Planning Application 3/2018/0050

Great Mitton and Bashall Eaves Parish Council Response

We have considered the application for the proposed change of use of agricultural land and development of ten holiday chalets on the land adjacent to The Beeches, Eastham House Farm, Great Mitton and following a site visit by the Parish Council committee we would like to make the following comments and recommendations detailed below.

Proposed Floor Plan - 1:100

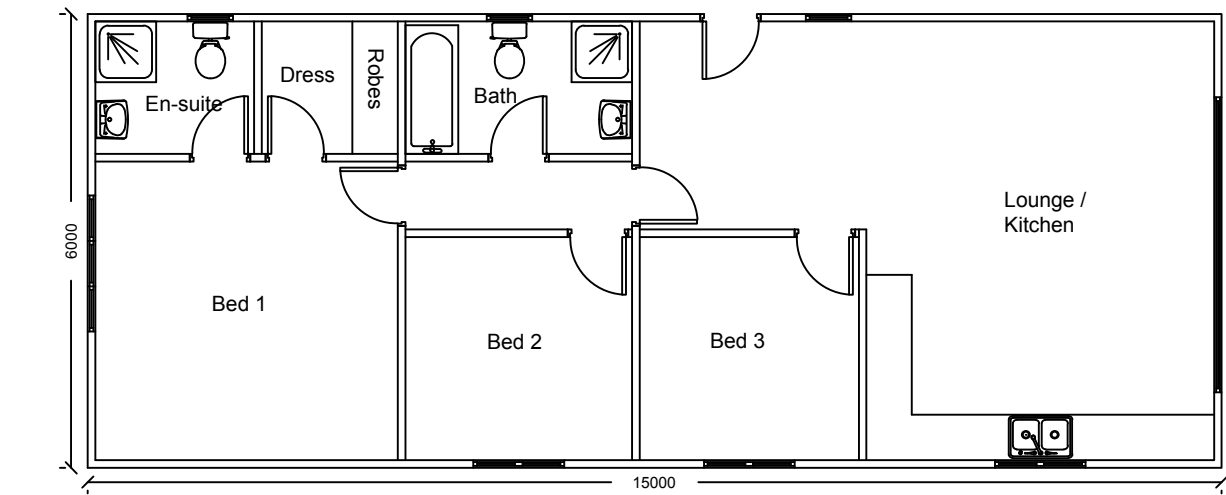
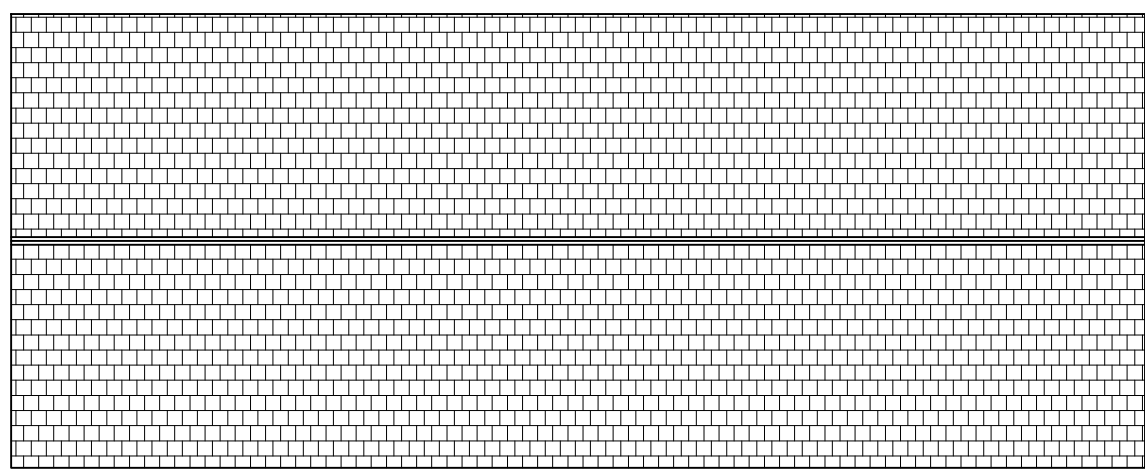
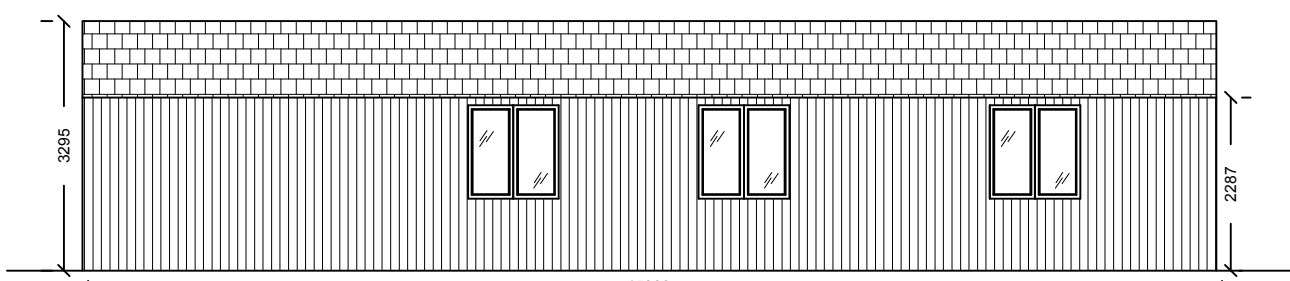
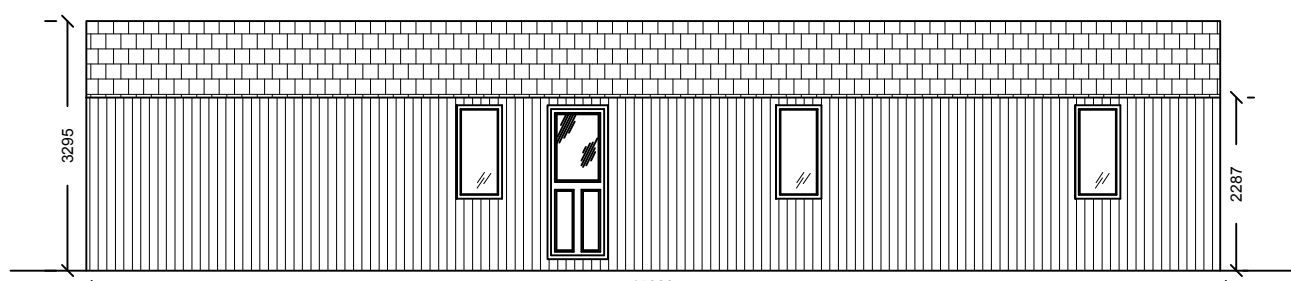
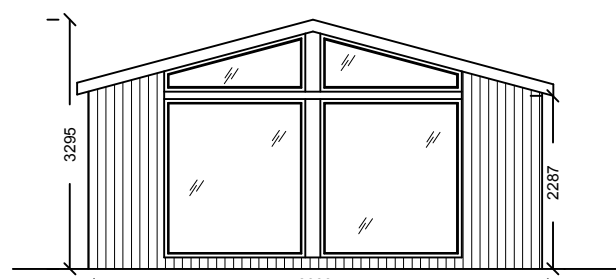
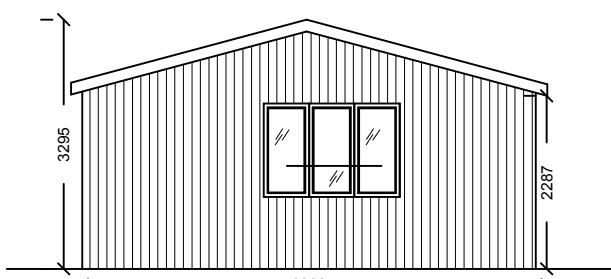
- The design of the lodges has little thought to the surroundings. We would expect more natural materials to blend with the countryside and a more of a lodge feel than a static trailer as is proposed. Other applications in the parish have led to shepherds huts, yurts and timber lodges which all blend well with the landscape and gives a more romantic feel.

Proposed Site Plan - 1:500

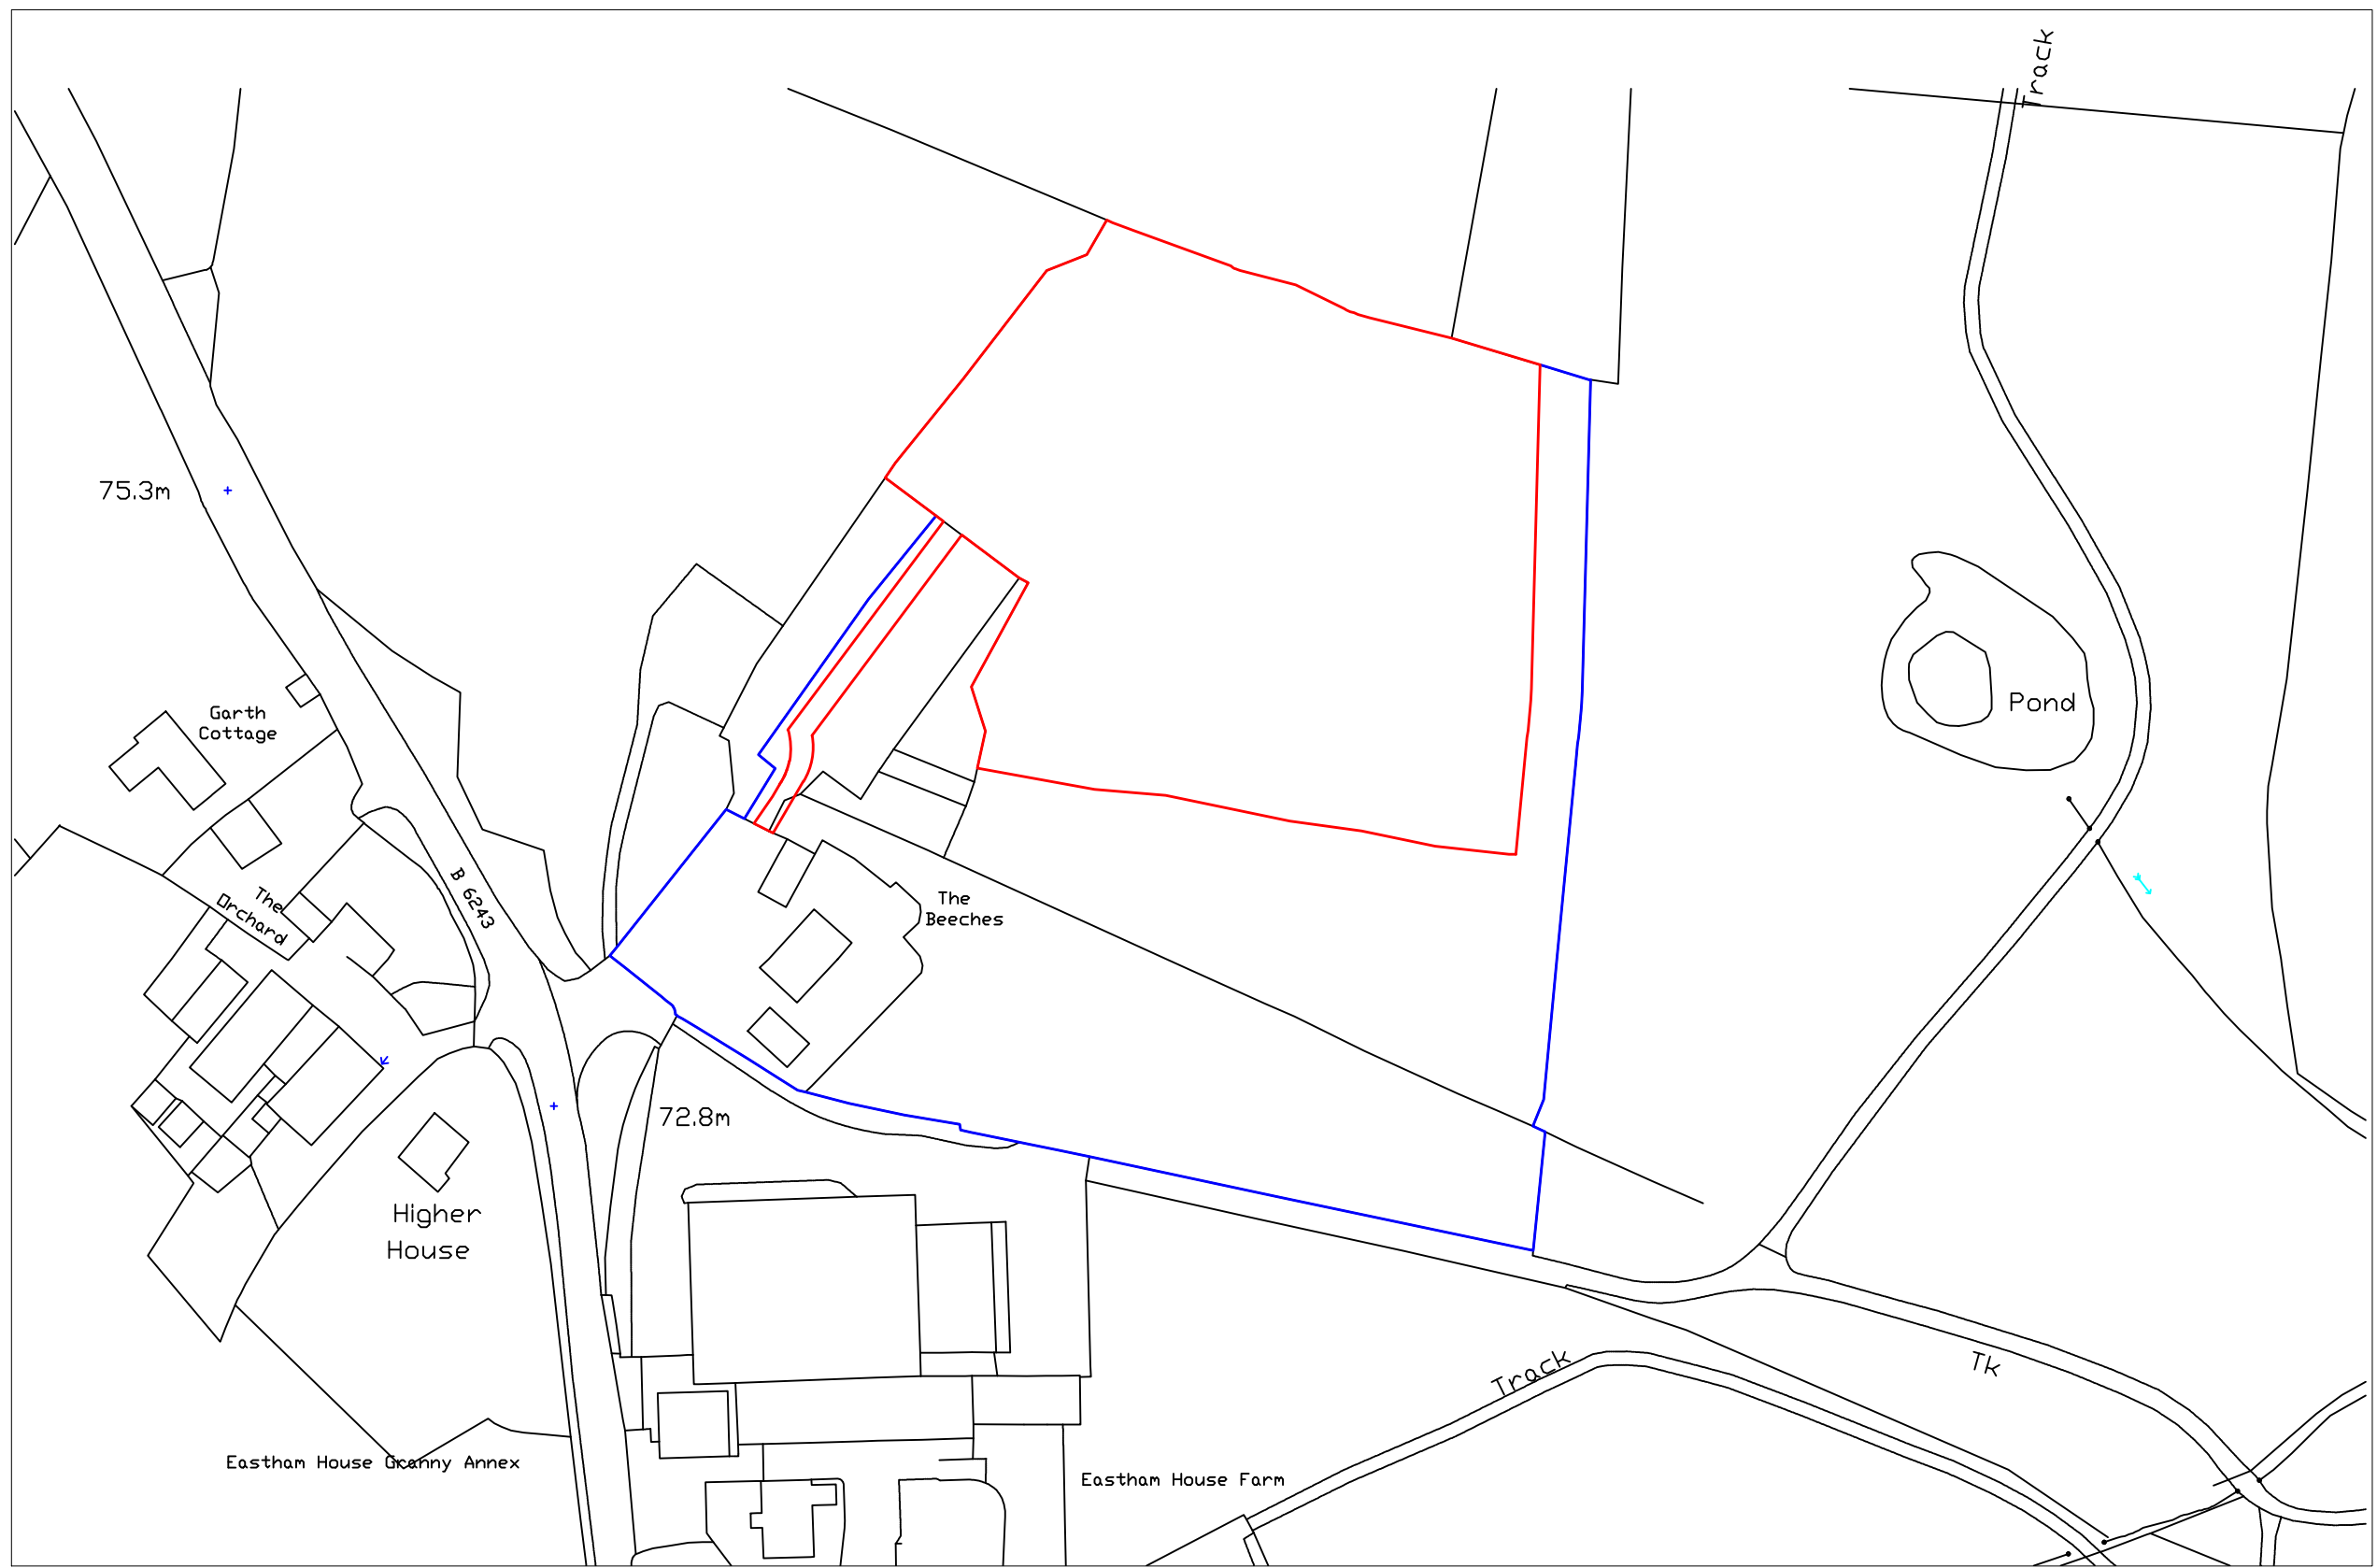
- With regards to the parking, provision has been made for 2 spaces per building. On the application there is a mention made of additional parking but this is not shown on the plan and there does not appear to be any additional space. Clarification is needed.
